Non-Material Amendment Application to planning permission 3/2022/0537: Land adjacent to Northcote Road, Langho BB6 8BG

On behalf of our client Alderley Group, please find enclosed an application for a Non-Material Amendment in respect of the above planning permission, submitted under Section 96A of the Town and Country Planning Act 1990 (as amended) (PP-13778867).

Drawing Title
BOUNDARY TREATMENT DETAILS

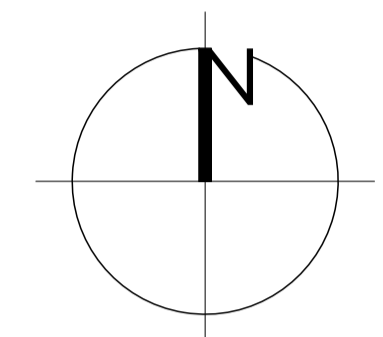
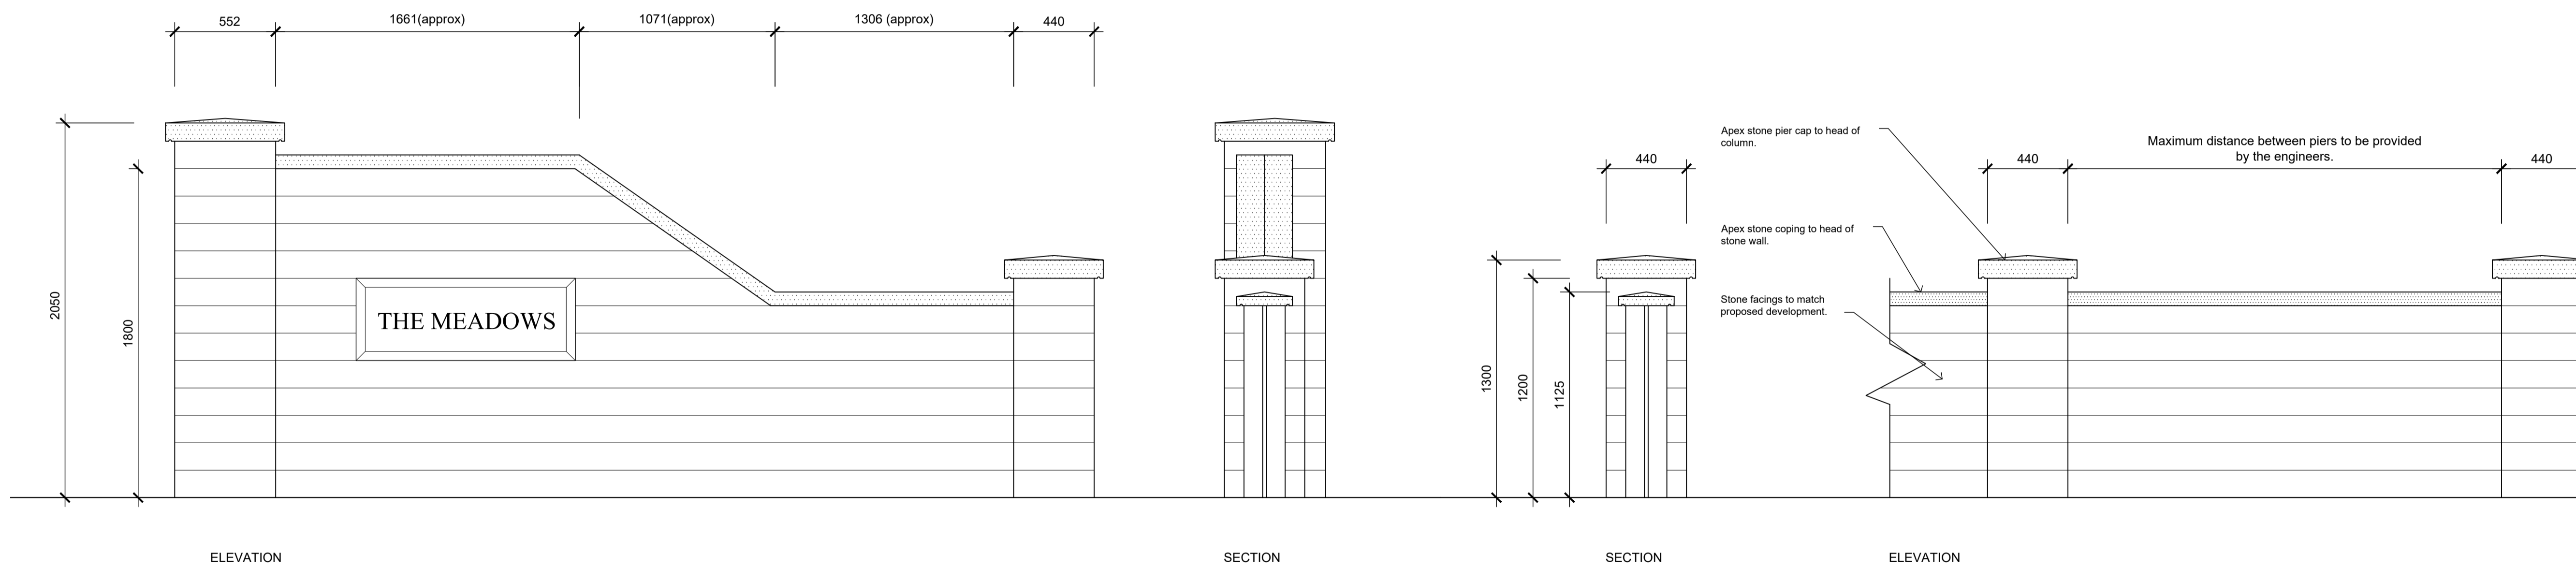
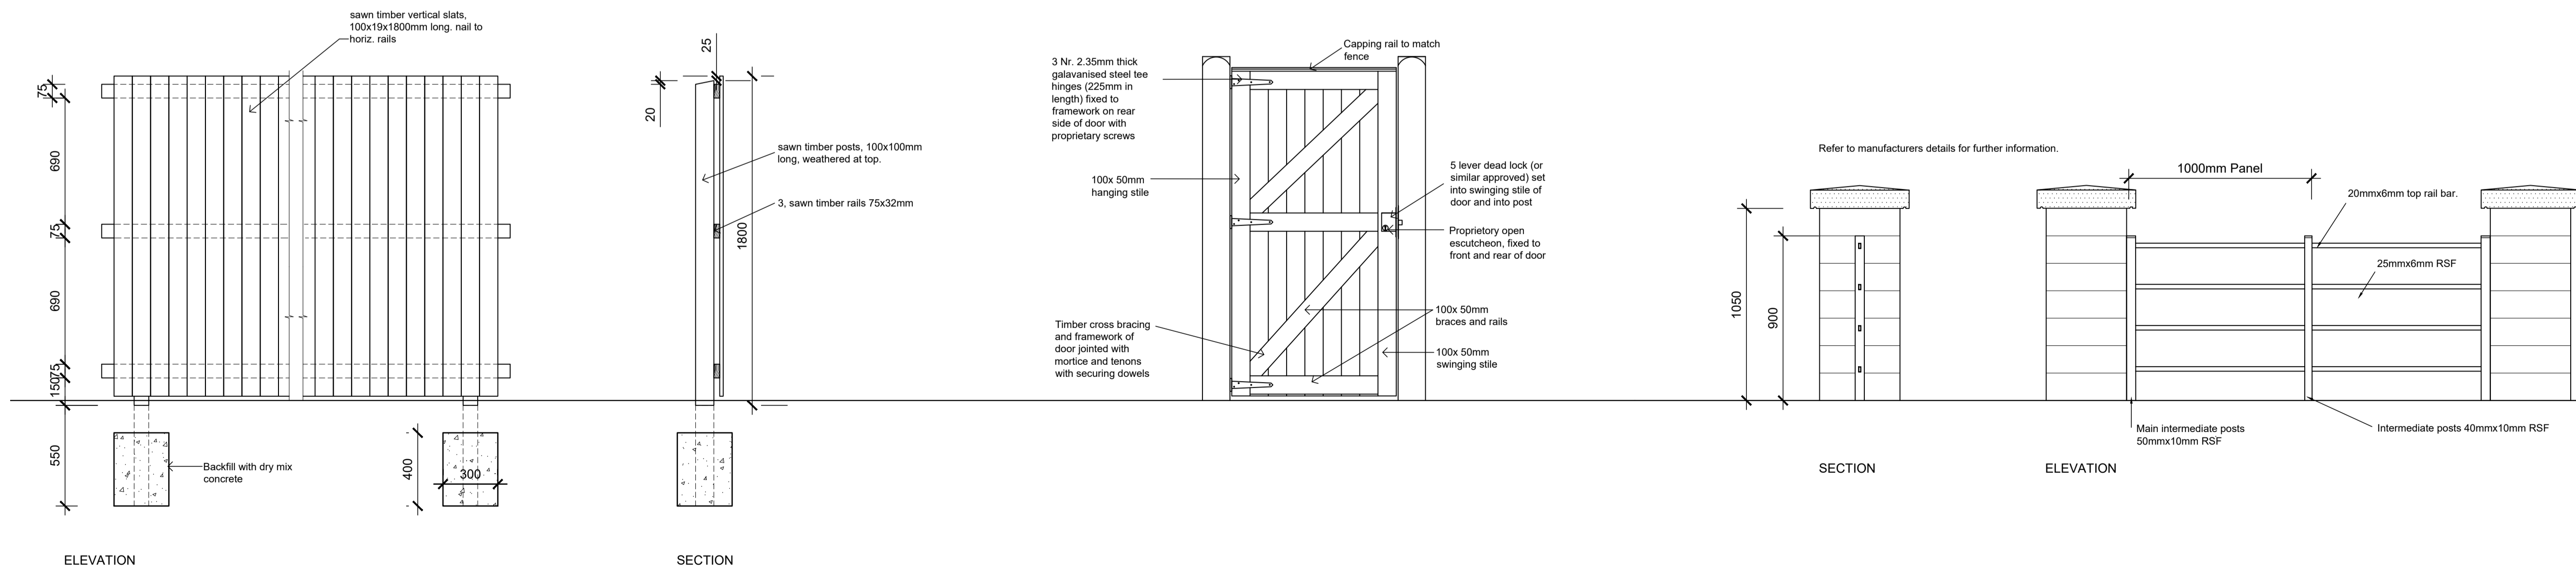
- Updated feature wall – ‘The Meadows’ - added to the side of the main entrance into the development.

Drawing Title: **PROPOSED SITE LAYOUT**

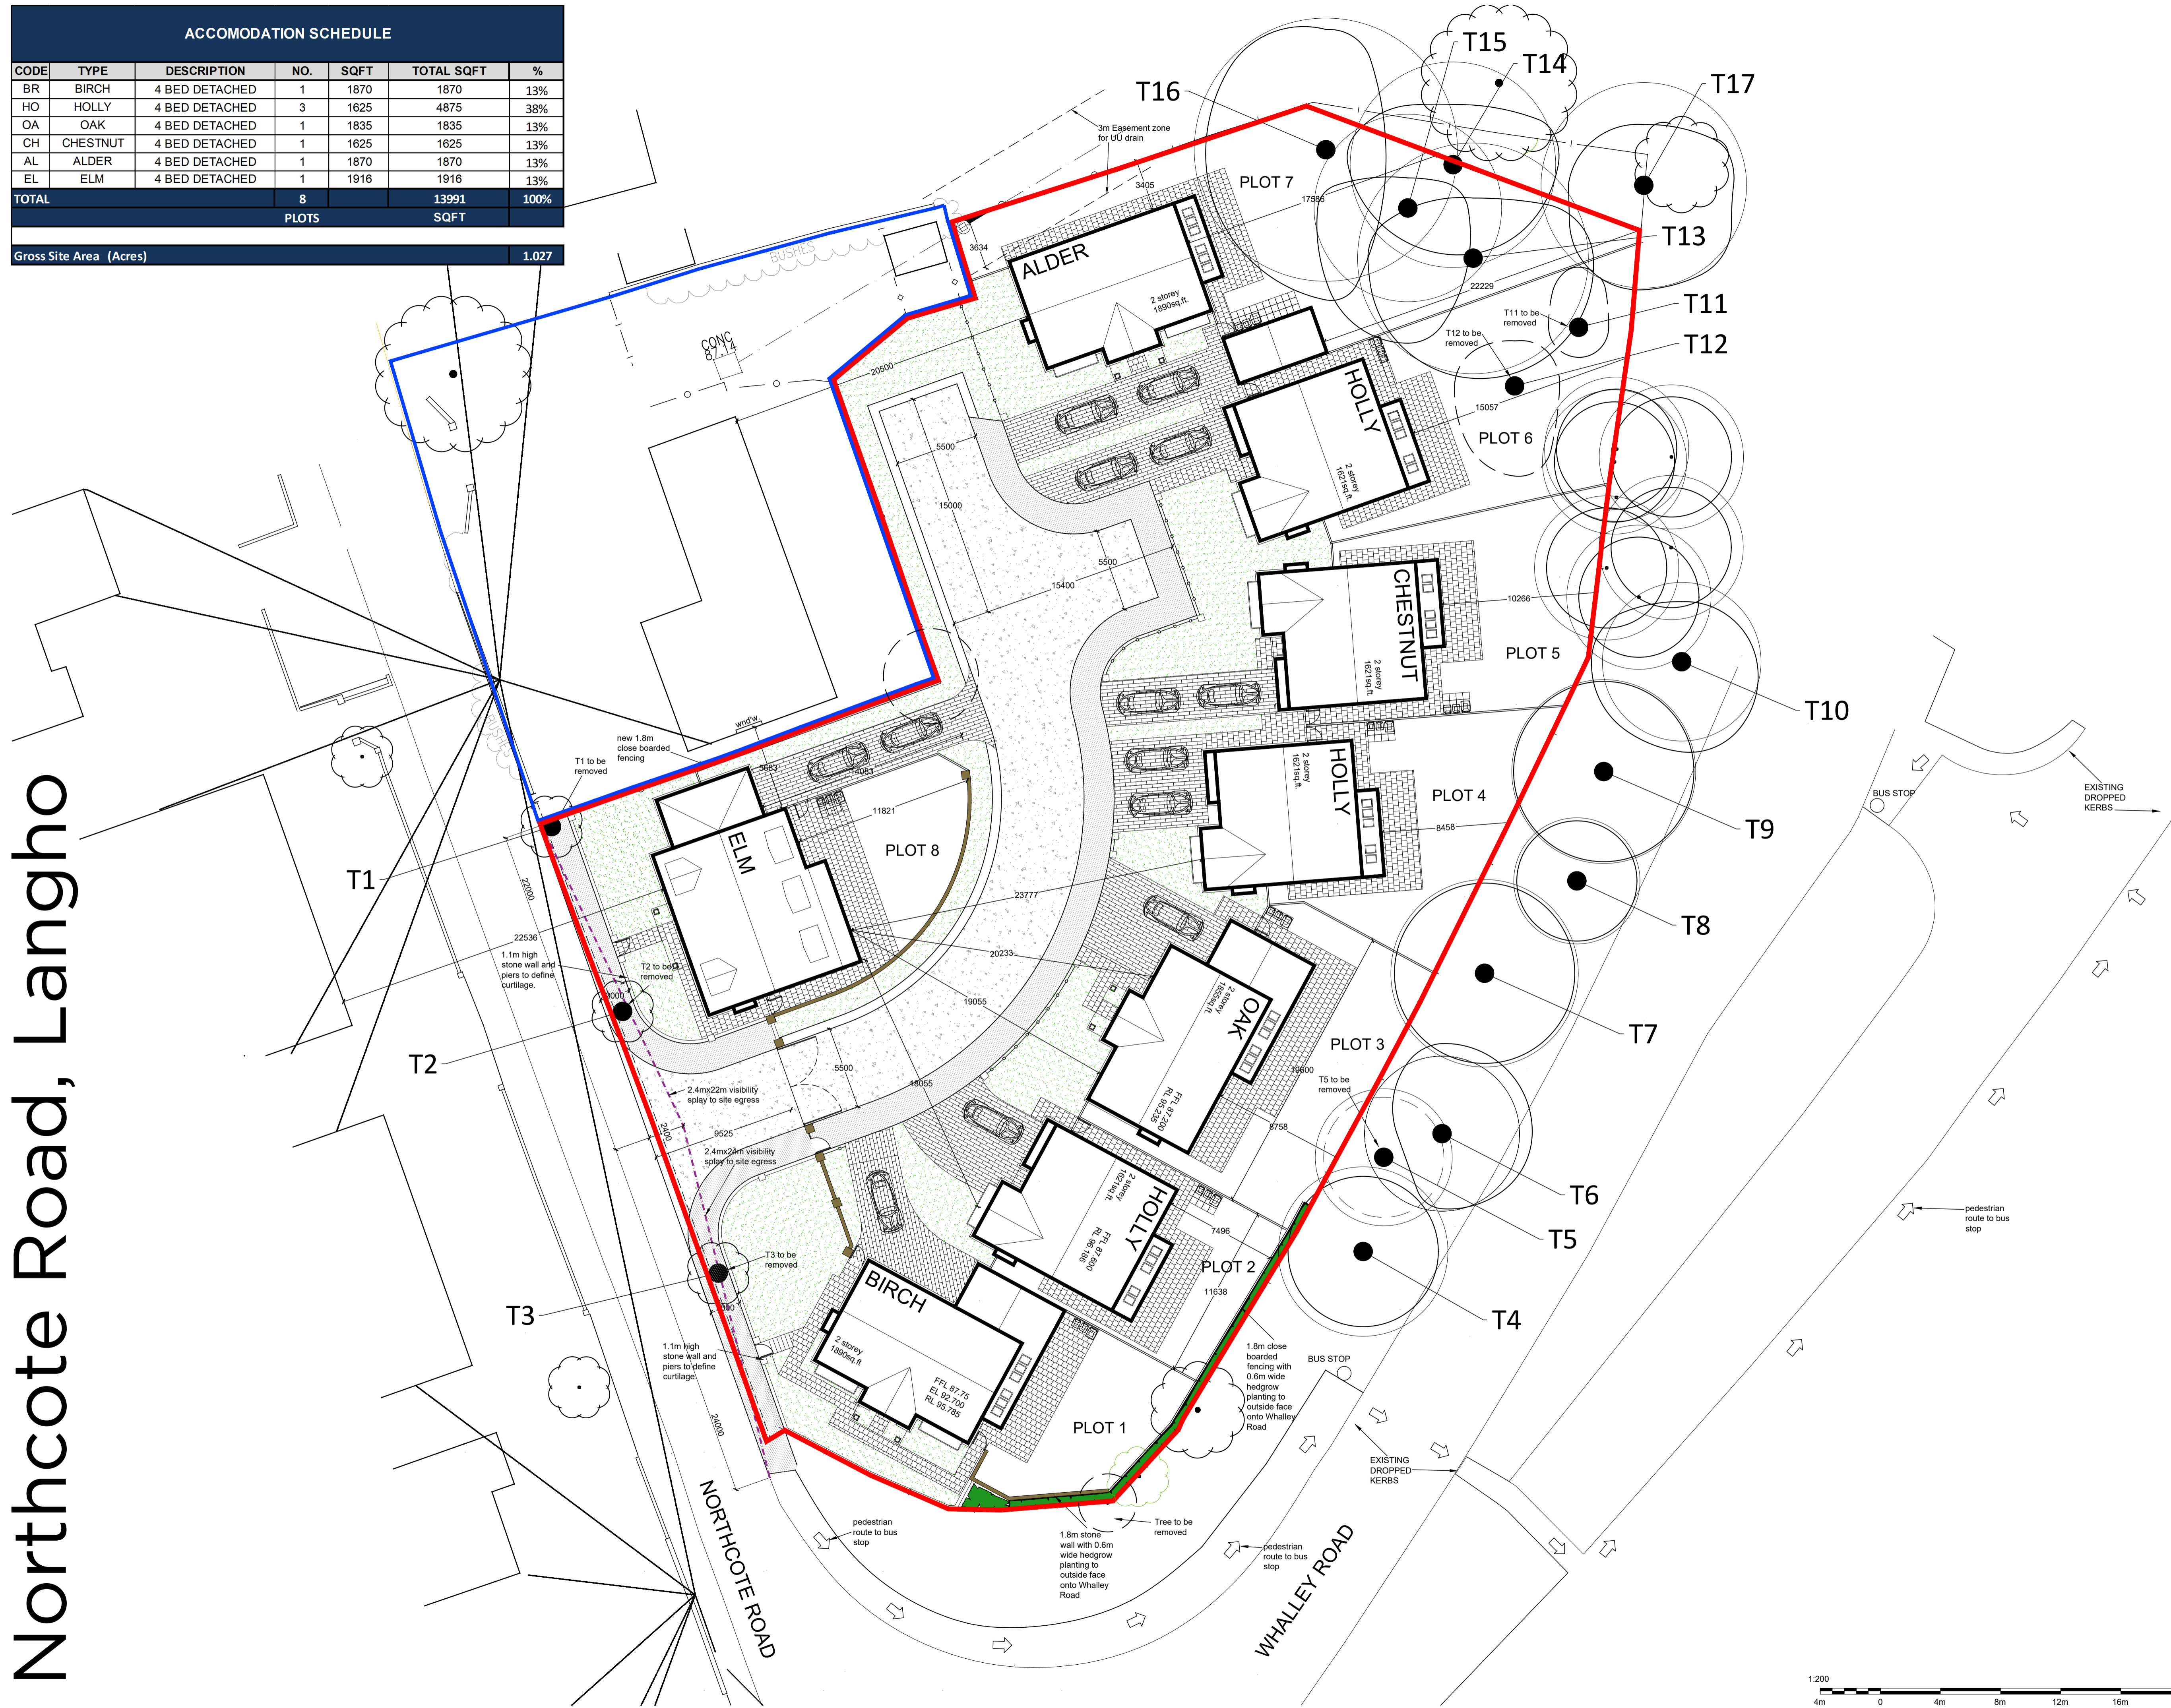
- Slight repositioning of the Plot 2 driveway.
- Adjusting the position of Unit 7, to move it 1.5m eastwards into its plot, in order to avoid an existing drainage line.

Unit 7 would move 1.5m east to avoid the alignment of a private drain. This increases the separation distance retained to the existing, neighbouring property to the west, without having any material knock-on effects on other properties / the streetscene. The revision to its garage roof will lower the overall height of this part of the dwelling by 400mm.
